Mr Clare has raised a number of concerns he has with *MP 06_0250 MOD 9 - modification to the residential subdivision for 411 lots at Seaside Boulevard, Fern Bay* which is currently being considered by the Department of Planning & Environment.

Objections to Modifications to Project Approval for Seaside Boulevard Fern Bay

Application for Modification MP06_250 MOD9 - Seaside Boulevard Fern Bay

DRAWING TITLE
STAGING & LOT LAYOUT REV-1
PROJECT PLAN L
FERN BAY SEASIDE VILLAGE
NELSON BAY ROAD, FERN BAY
CLIENT
RAWSON COMMUNITIES PTY LIMITED

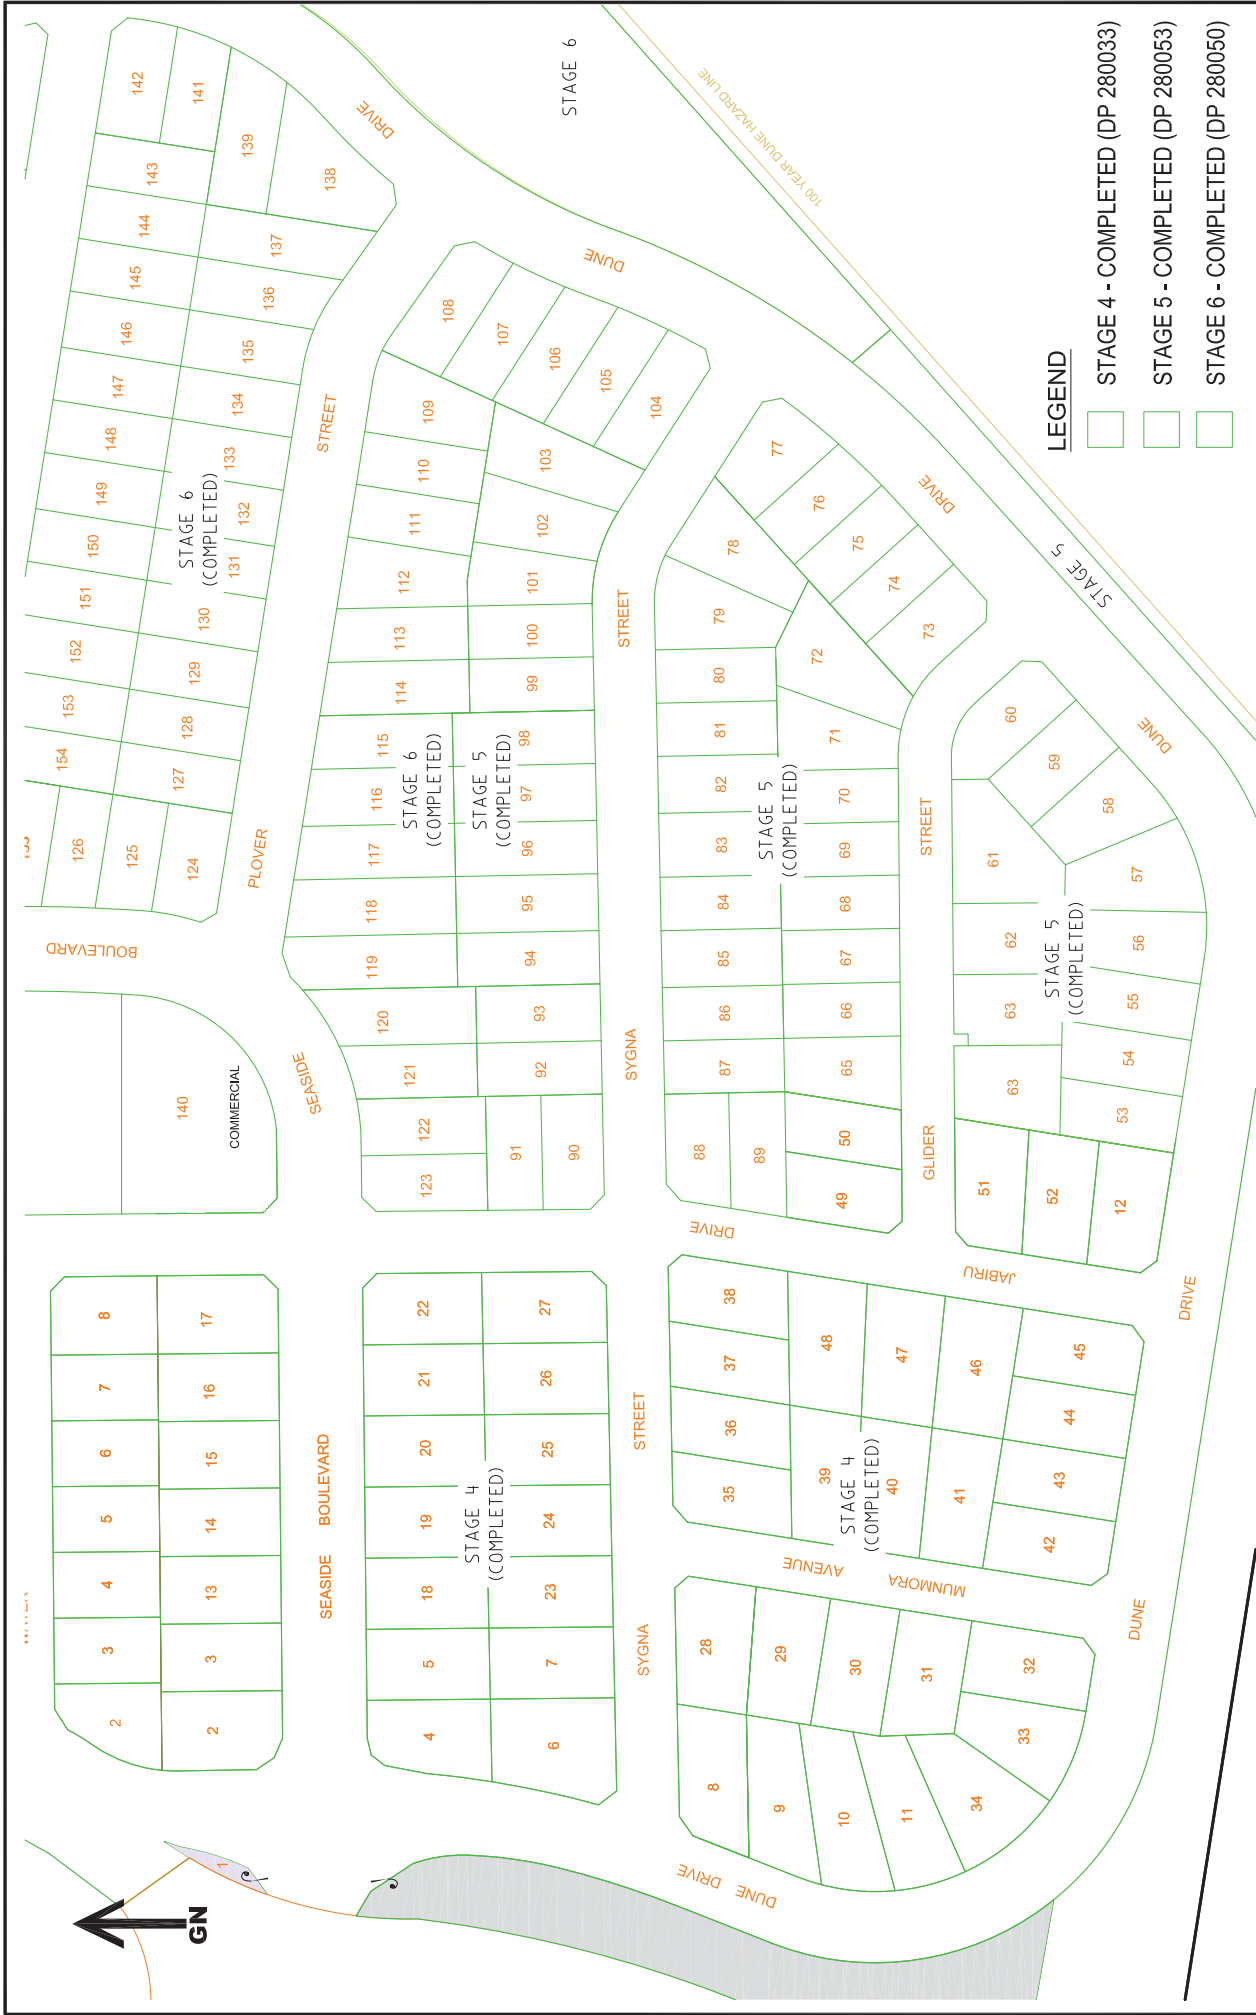
I **strongly** object to changing the second general access road to an Emergency ONLY Track.

The justification for the removal of condition B5 provided by the proponent (Rawson) based on traffic survey results during morning and afternoon traffic patterns are completely false. It is not valid to equate normal peak traffic volumes and roundabout capacity with an emergency evacuation of the entire population of Seaside Estate.

From this analysis the second access must interconnect with Nelson Bay Road with a full two-lane roundabout, that is a duplication of the Seaside Boulevard roundabout.

Because of the huge increase in the number of dwellings now under construction in Seaside, rather than proposing a **downgrading** of the general access, the proposal must be to **upgrade** the second access to Nelson Bay Road with a new roundabout.

SCALE	1: 1000	DRAWING TITLE	STAGES 18 & 19 DETAIL PLAN REV L
REVISION DATE	01/11/2016	DEVELOPMENT	PROJECT PLAN L
PLOT DATE	01/11/2016	DRAWN/CHKD BY	FERM BAY SEASIDE VILLAGE
DA NUMBER		IMC / AED	NELSON BAY ROAD, FERN BAY
		CC NUMBER	CLIENT
			RAWSON COMMUNITIES PTY LIMITED

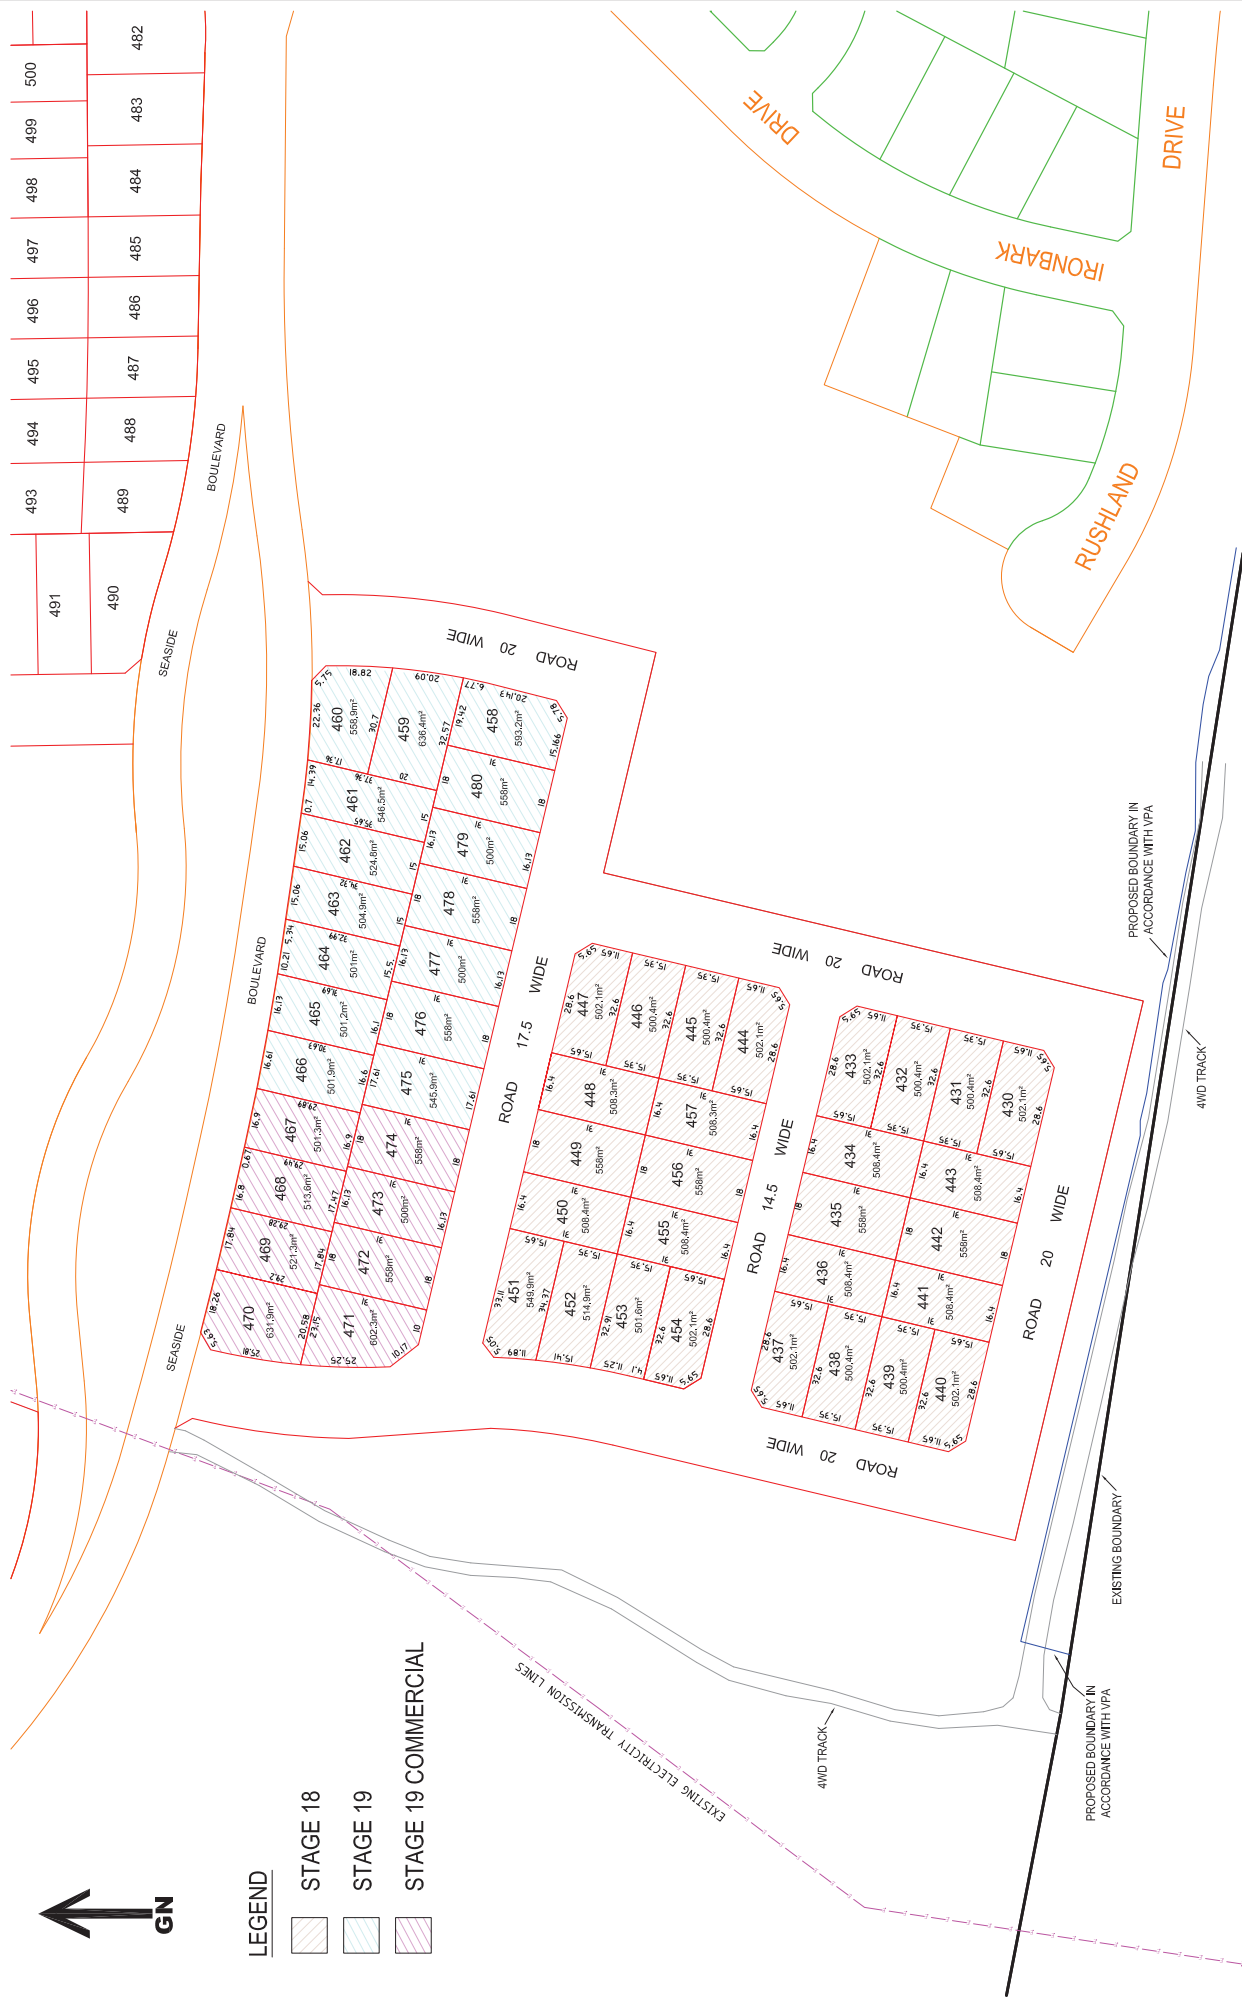
I **strongly** object to the changes to the lots layouts in stages 18,19 and 20 as these changes remove all the super lots with designations as in "B1 Neighbourhood Centre" into standard dwelling lots.

The **strong** objection is to the complete destruction of the original design concept of Neighbourhood facilities with lot sizes that would make any commercial development unviable. For example the normal strip shopping provides convenient parking for customers. There is no provision for customer parking.

The commercial lots in Stage 19 are on Seaside Boulevard on the exit road such that any local customer would be forced to drive out to the Nelson Bay roundabout to return to Seaside Estate again.

Seaside Boulevard is at its widest point of separation for the access road in and out of the Estate. For traffic flow to work around this commercial zone a new roundabout should be provided to enable local traffic to remain local.

I **strongly** object to the increase in the number of lots because the increase is at the expense of the original design of Neighbourhood facilities and destroys forever the only land in these super lots that could provide facilities for the community.
